REX CHRISTOPHER PLUMMER  
99 LOUEE STREET,  
RYLSTONE, NSW 2849  
28 MARCH 2022

APPLICATION NAME: BOWDENS SILVER MINE AMENDMENT  
APPLICATION NUMBER: SSD5765  
**BLAST FUME**

Figure 2.8
WASTE ROCK EMPLACEMENT
LAYOUT AND SECTION

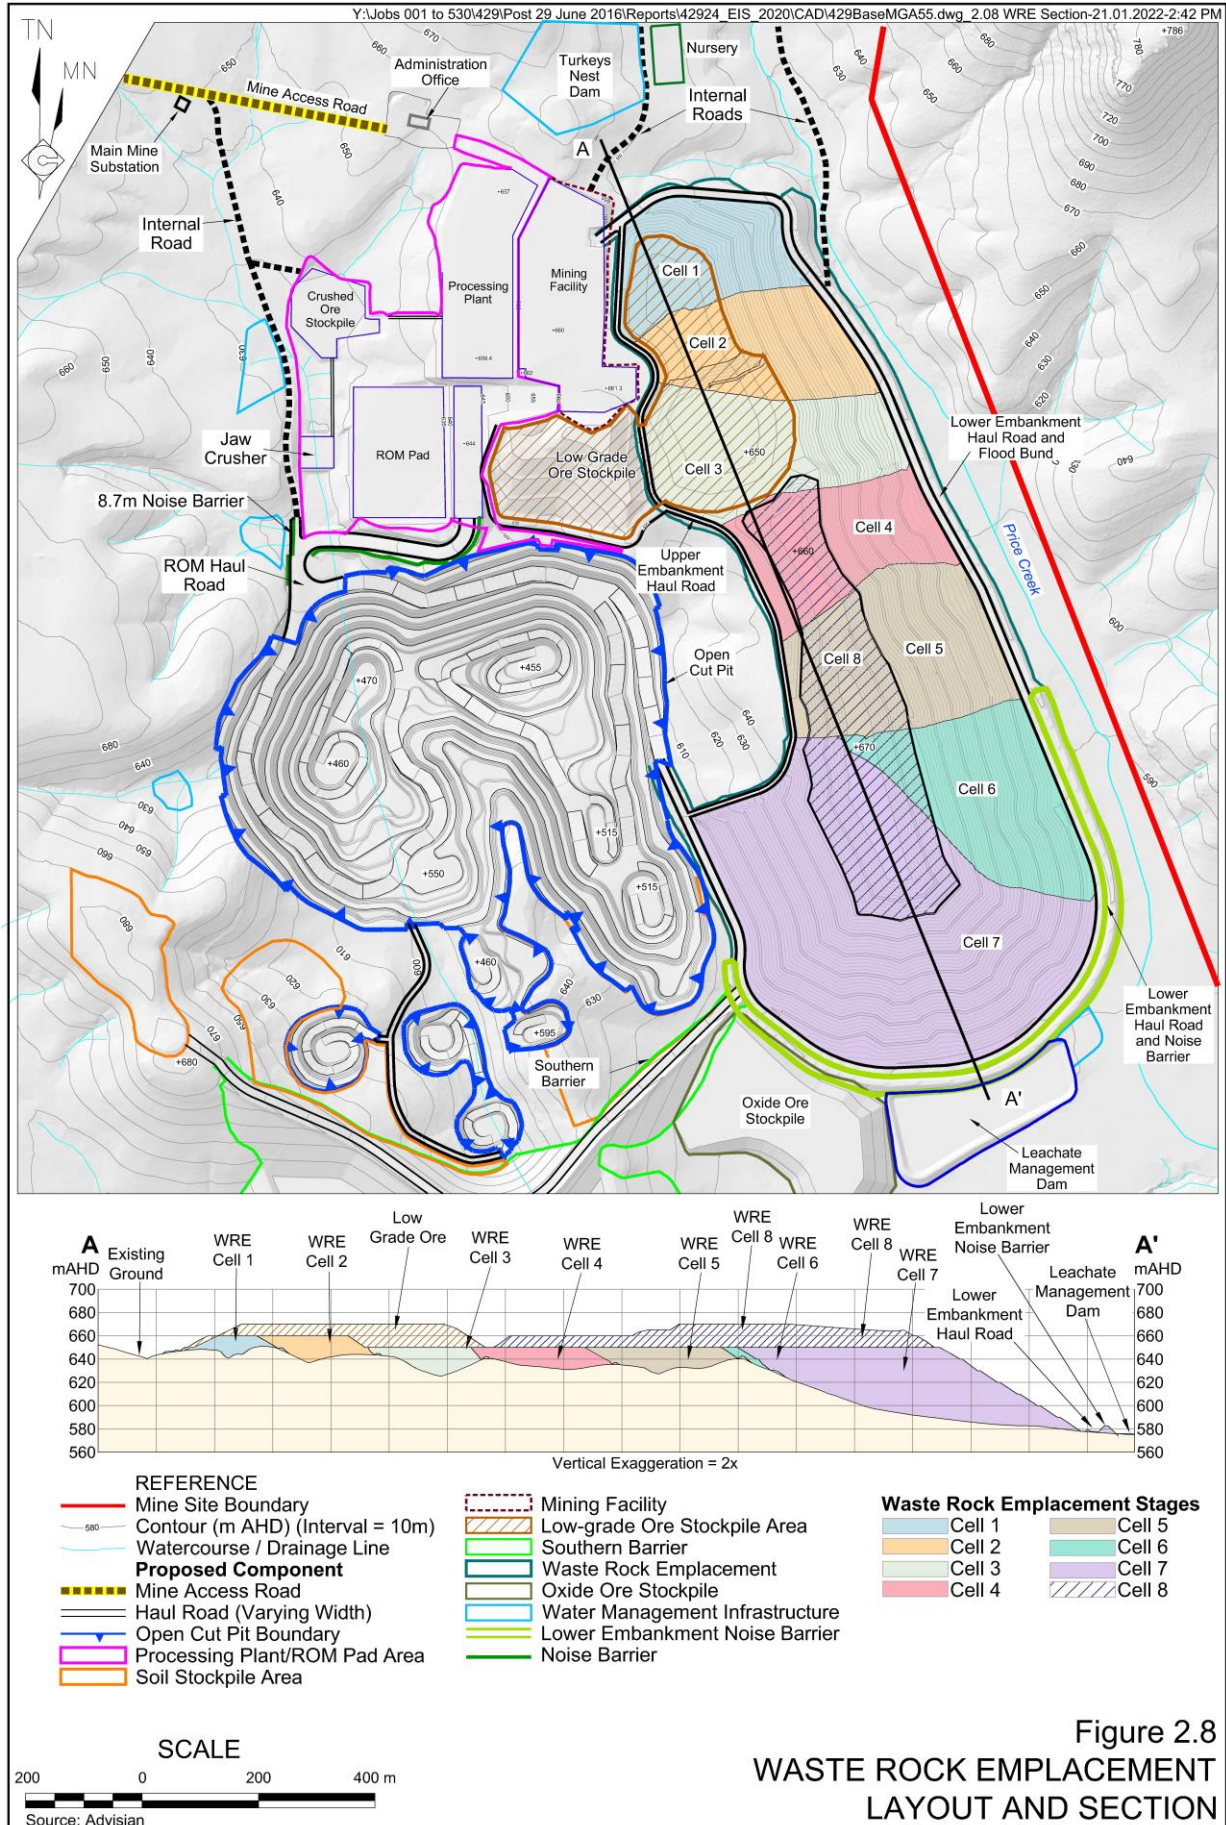
Elsewhere I have made comment on the Bowdens immoral refusal to rehabilitate the WRE. In other words that Bowdens will leave the WRE as an unnatural geometric pyramidal monolith with constant grade surface slopes and a near flat ridge roughly a kilometre in length. This sand castle or roof-like shape will never look like or replicate the natural form of the hills to the immediate east.

The huge and lasting impact is the view from Lue Road on Lochiely flats. It will be a conical section with a horizontal ridge poking up into a naturally convoluted rocky landscape. Naturally Bowdens have not issued any graphic to show this impact.

There are **no sections** drawn from Lue Road across to and beyond the WRE. Why not? Because it will reveal the real negative visual impact.

Figure 2.11
LOW GRADE ORE STOCKPILE

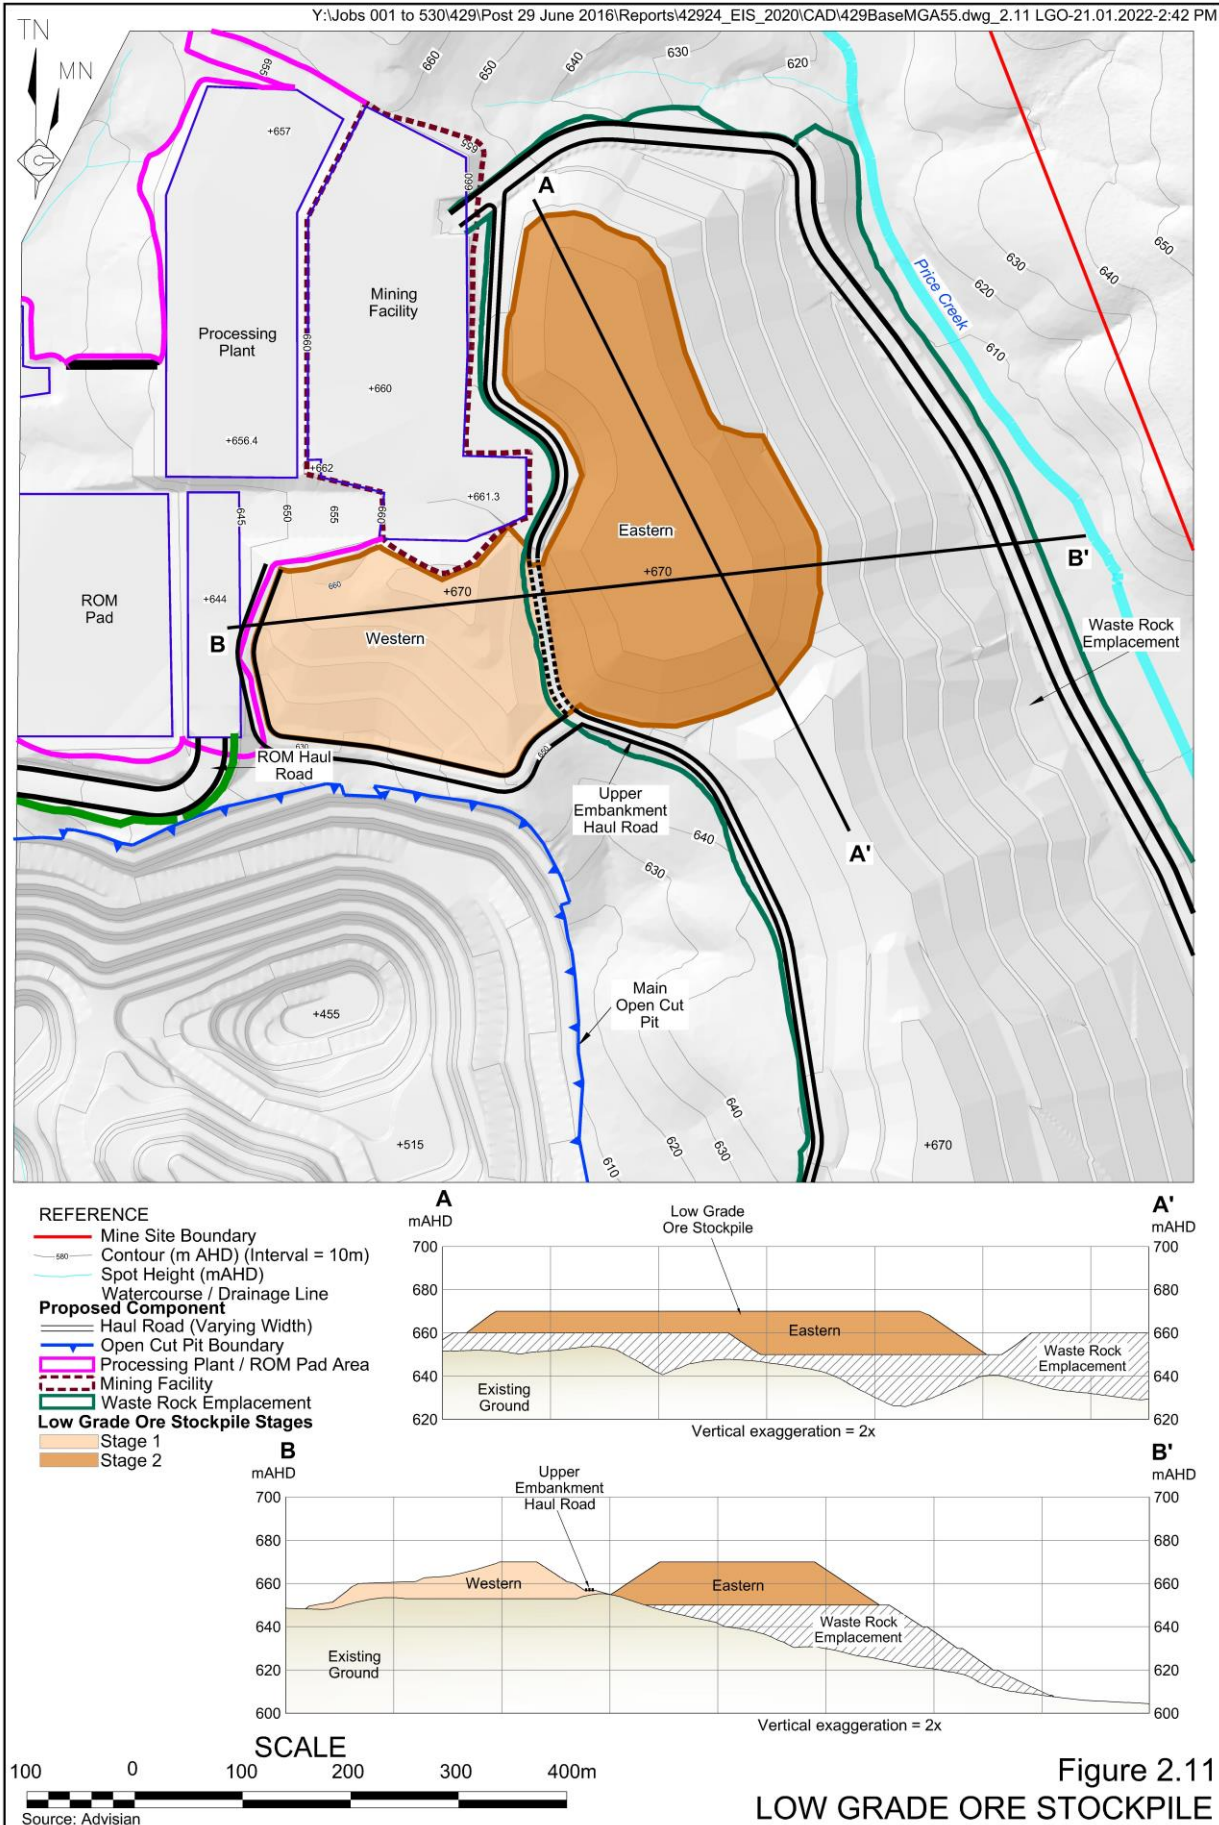
Low Grade Ore may have little content of the target metals but it is still essentially derives from Sulphide Ore (Galena). It will be stockpiled, around 2.7 million tonnes, in the open and unsealed, near the north end of the WRE. 2.6.1.2 (GCA 2020) confirms it as PAF. Probably quite certainly Acid-forming rock and nearly 3 million tonnes of it. It is ripe for weathering as broken rock with freshly exposed faces.

These open deposits 'may' be processed at some stage (not planned or committed by Bowdens). Otherwise they are open to water (rain and runoff), oxygen and inoculation by *Acidithiobacillus* thus forming uncontrolled runoff of acid (Sulphuric Acid).

Bowdens have made detailed plans for permanent encapsulation of PAF in the WRE. But Low Grade Ore is also PAF. They are choosing to ignore 2.7 million tonnes of sulphide ore and certainly doing nothing about it for 16.5 years. Acid could leach into the Macquarie system for hundreds of years
